Planning Services Sign Permit Review Form

Date of Submittal	Application Number	Applicant	Landowner
03/26/19	SIGN 1903-0004	Robert V. Miller	Tamela Miller & Girona Nestor III Trustee
Contact Person	Contact Number	Sign Location	PIN Number
Robert V. Miller	919-495-1415	62 Joint Rd	0524-02-1705

# Reclamation Church

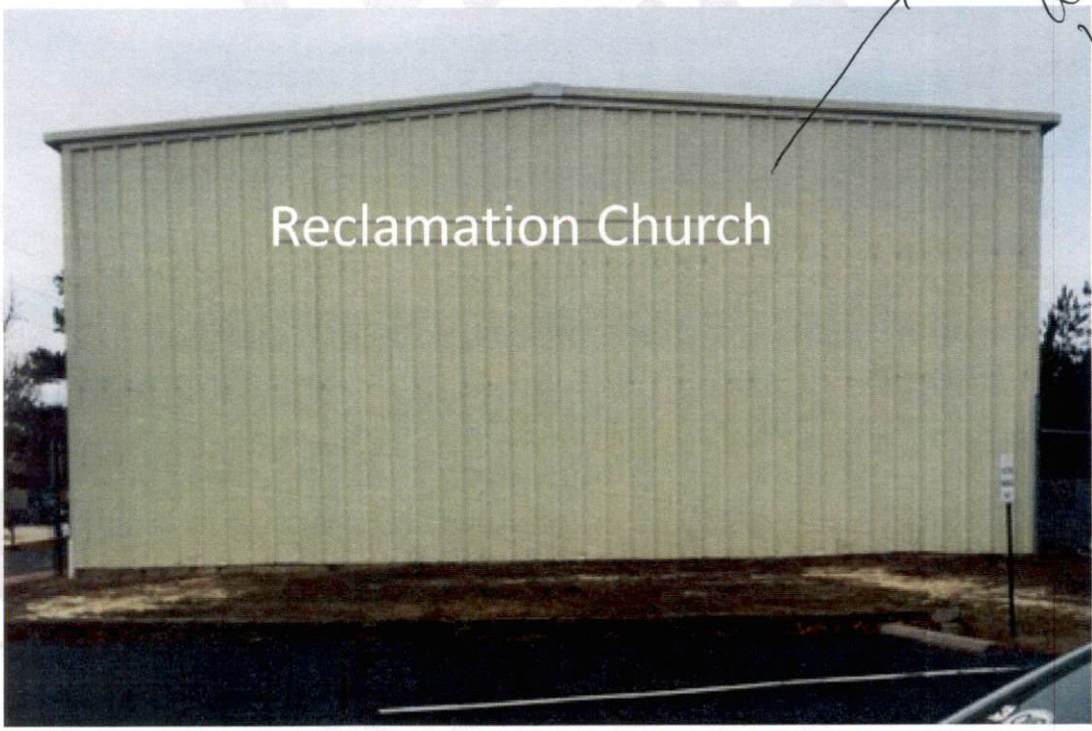
Comments	1 wall sign proposed to be affixed on the southeast building facade of 62 Joint Rd.
----------	---

Wall sign: 250" x 22"

$$= 20.83' \times 1.83'$$

$$= 38.1189 \text{ sq. ft. } = \text{ok } \checkmark$$
